Date: 28 April 2026

**Application by Fosse Green Energy Park Limited for an Order Granting Development Consent for the Fosse Green Energy Park Project.
Deadline 5 Submissions for Lincolnshire County Council (LCC)**

Comments on Deadline 4 documents

Drawing file: published-documents / EN010154-001021-6.2 Figure 3-2B Indicative Single Axis Tracker Site Layout Plan (Rev 3).pdf

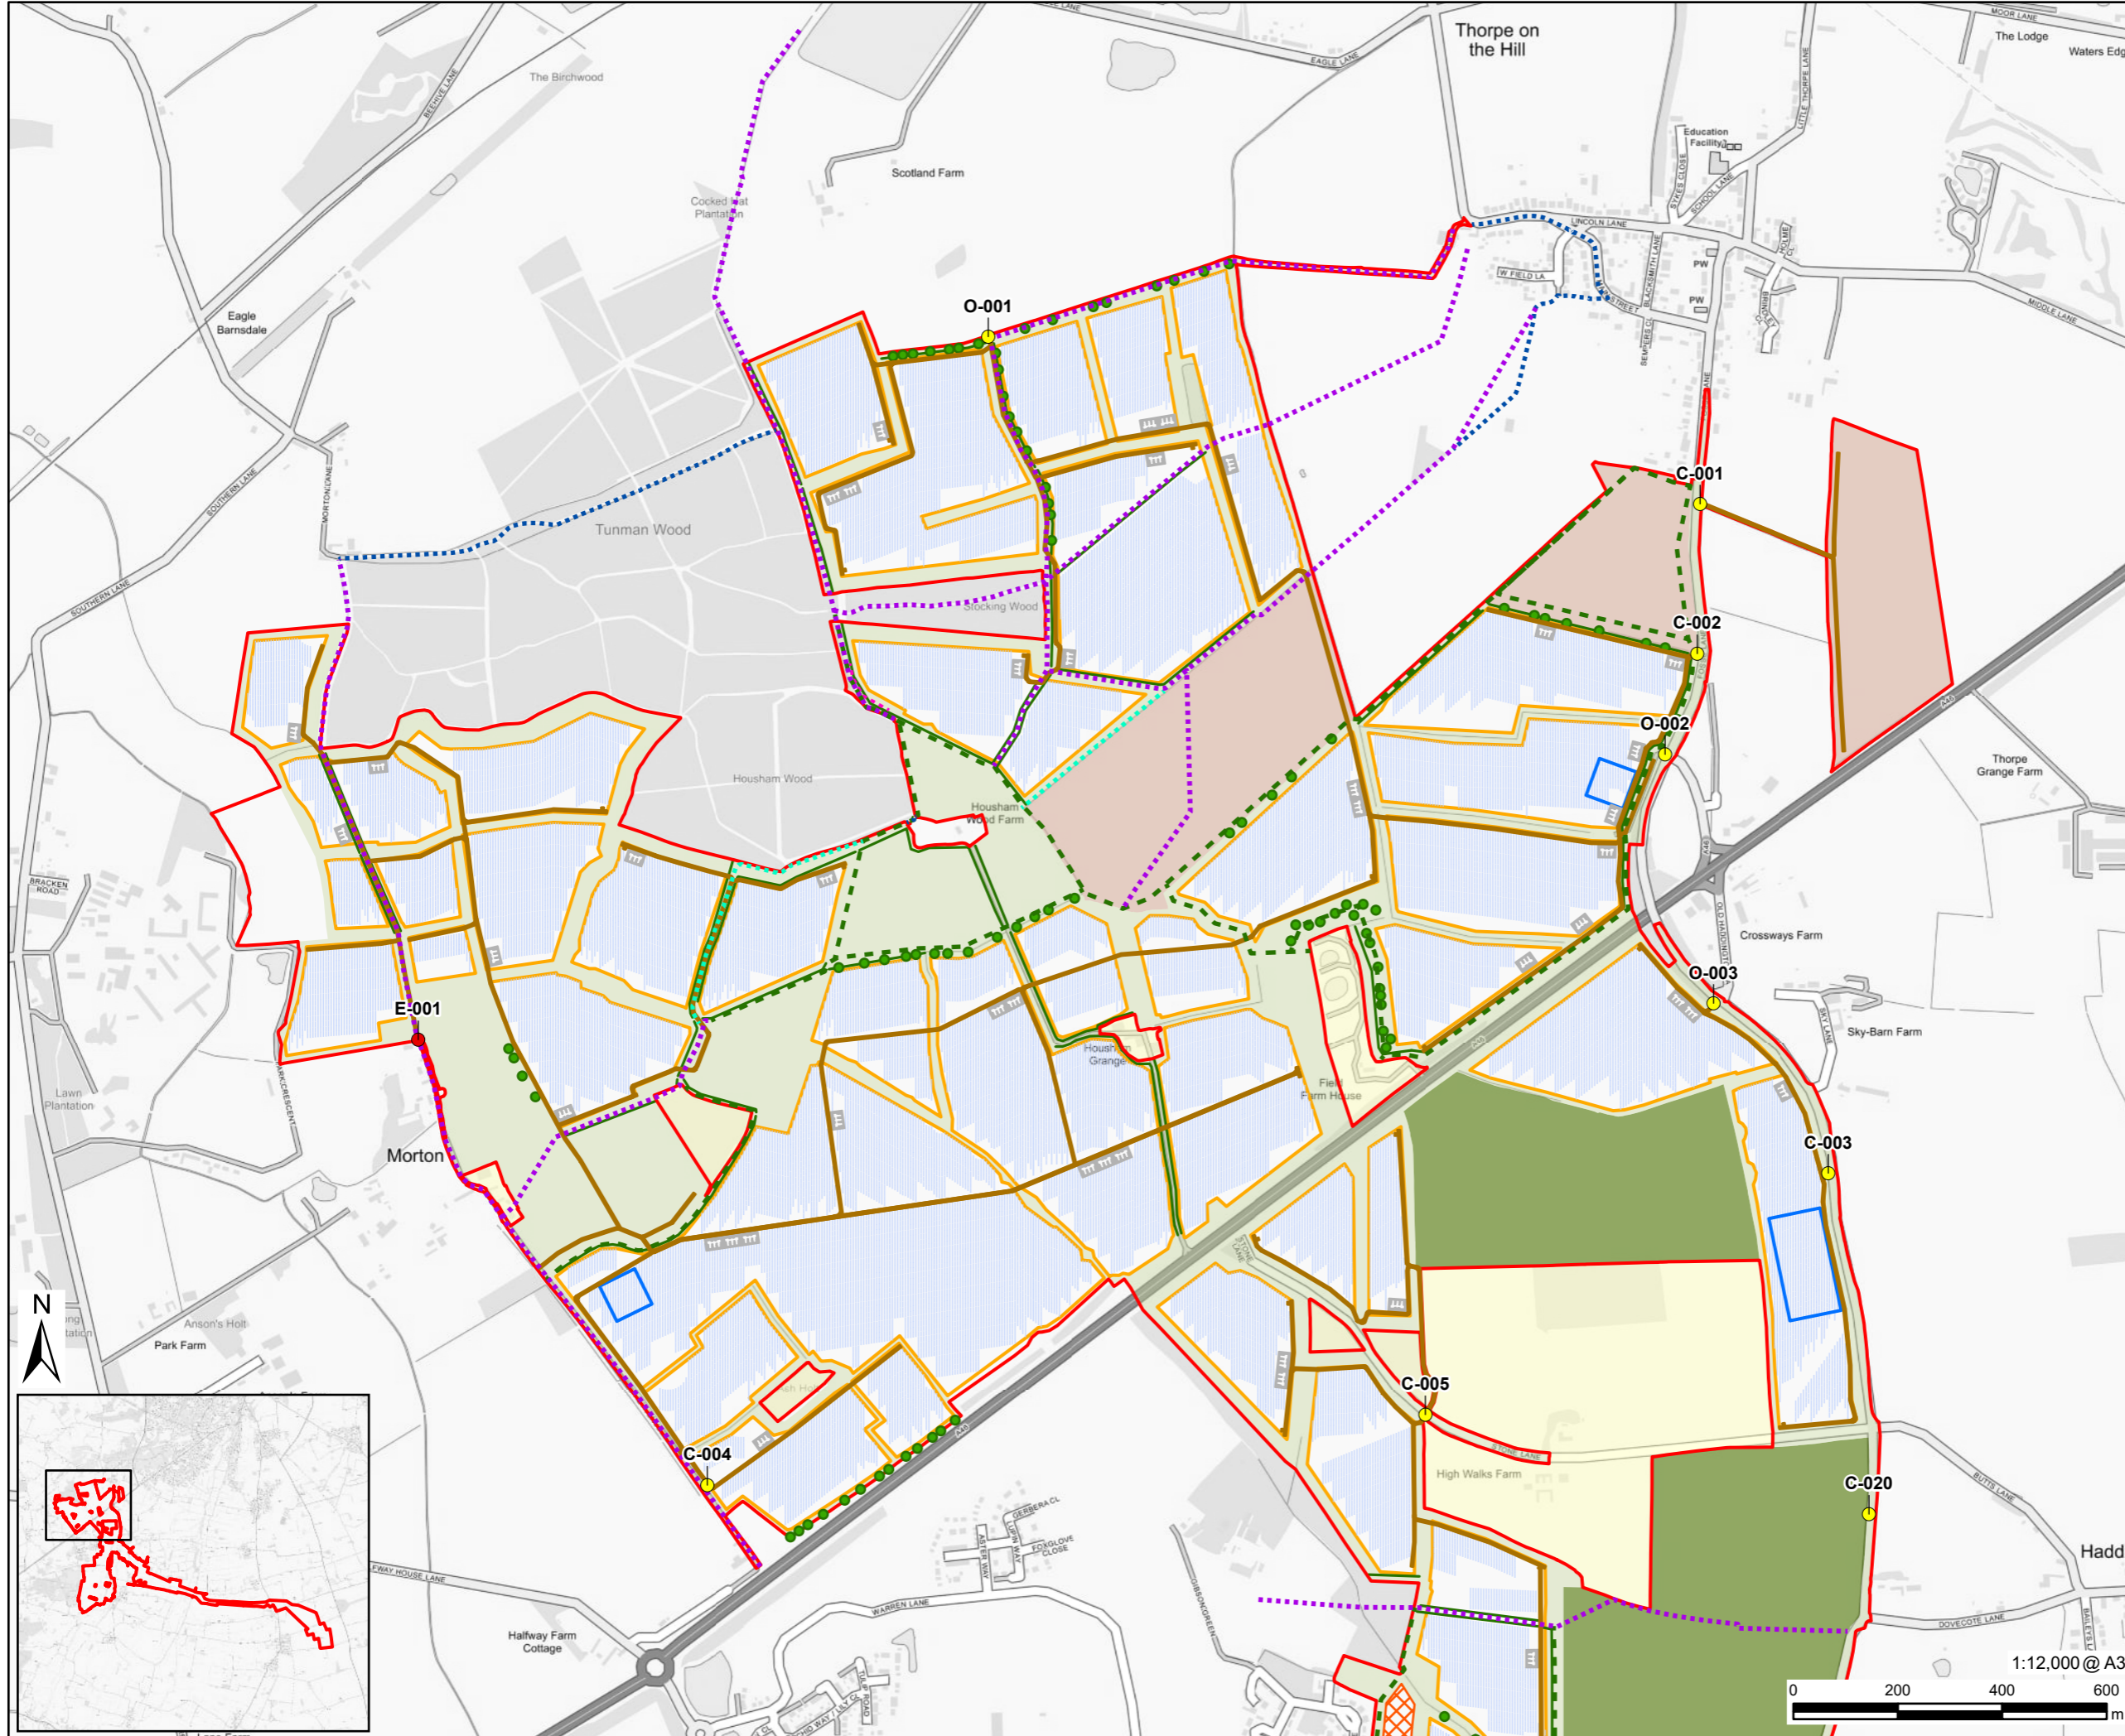
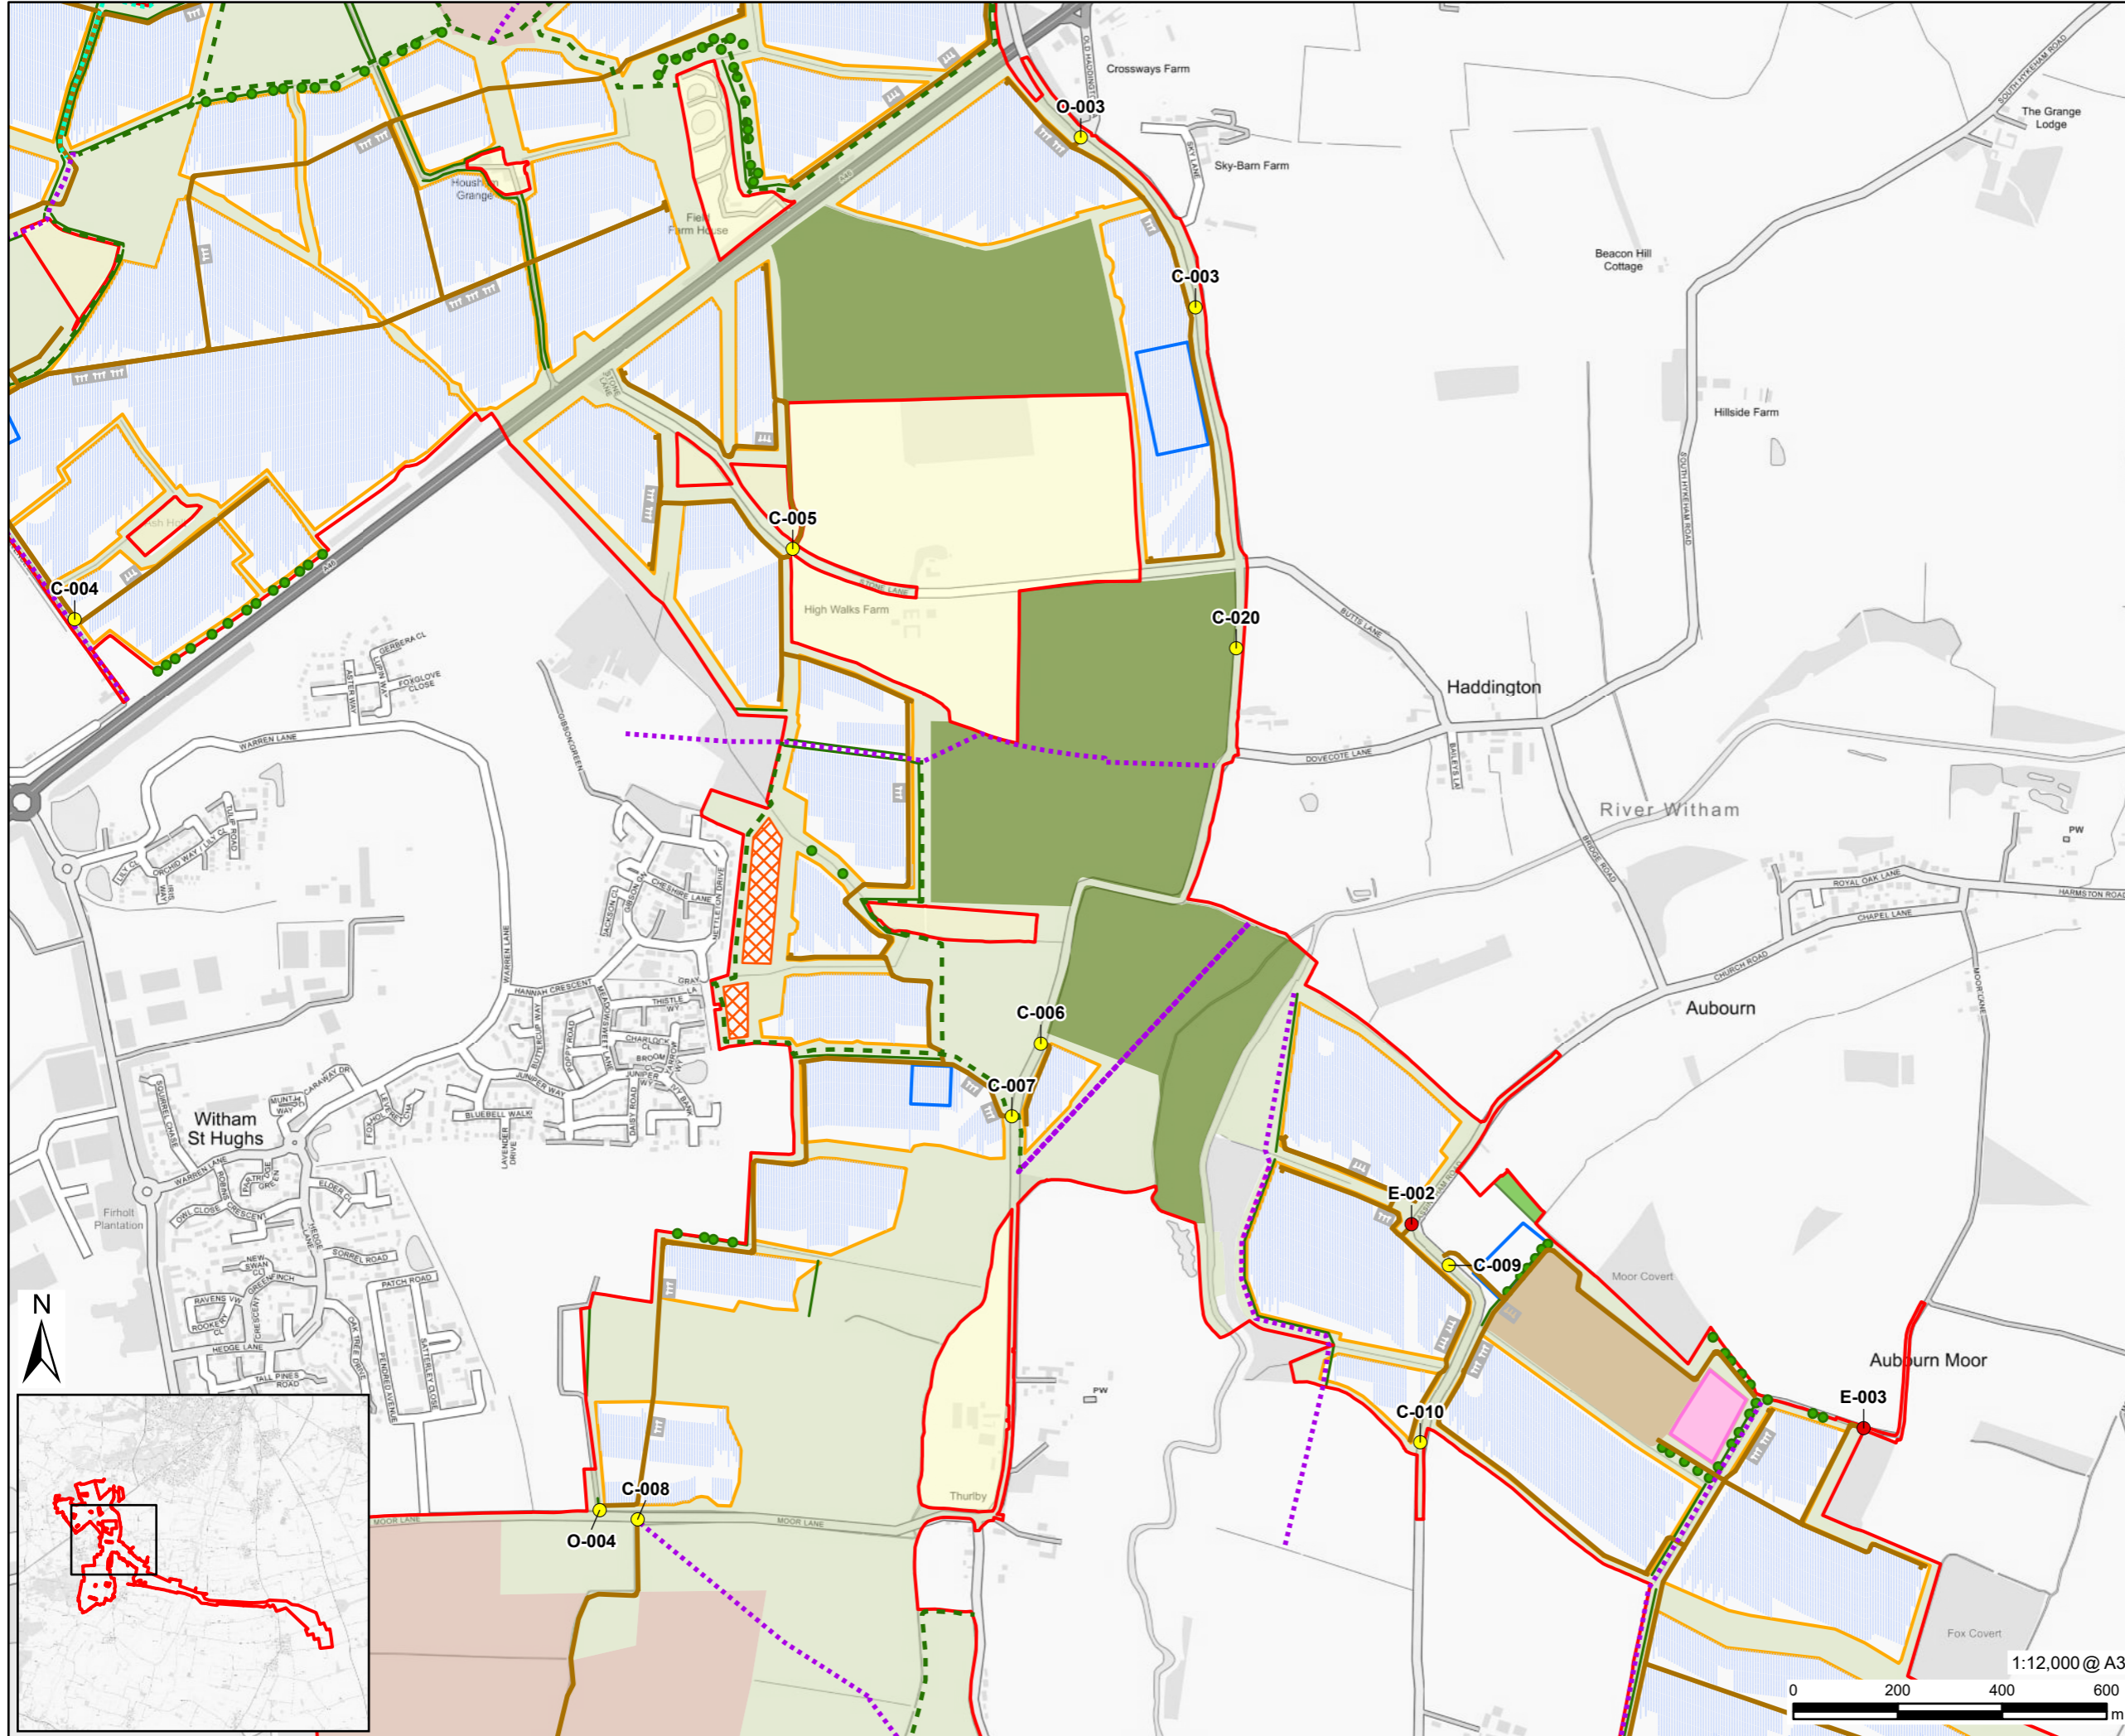
Site Layout Plan Revisions - Indicative Fixed South Facing Layout (Rev 3) and Indicative Single Axis Tracker Layout (Rev 3) [REP4-006 & REP4-007, respectively]

LCC assumes that the overall red line boundary remains unchanged, and thus LCC's previous comments in respect of minerals & waste safeguarding remain unchanged.
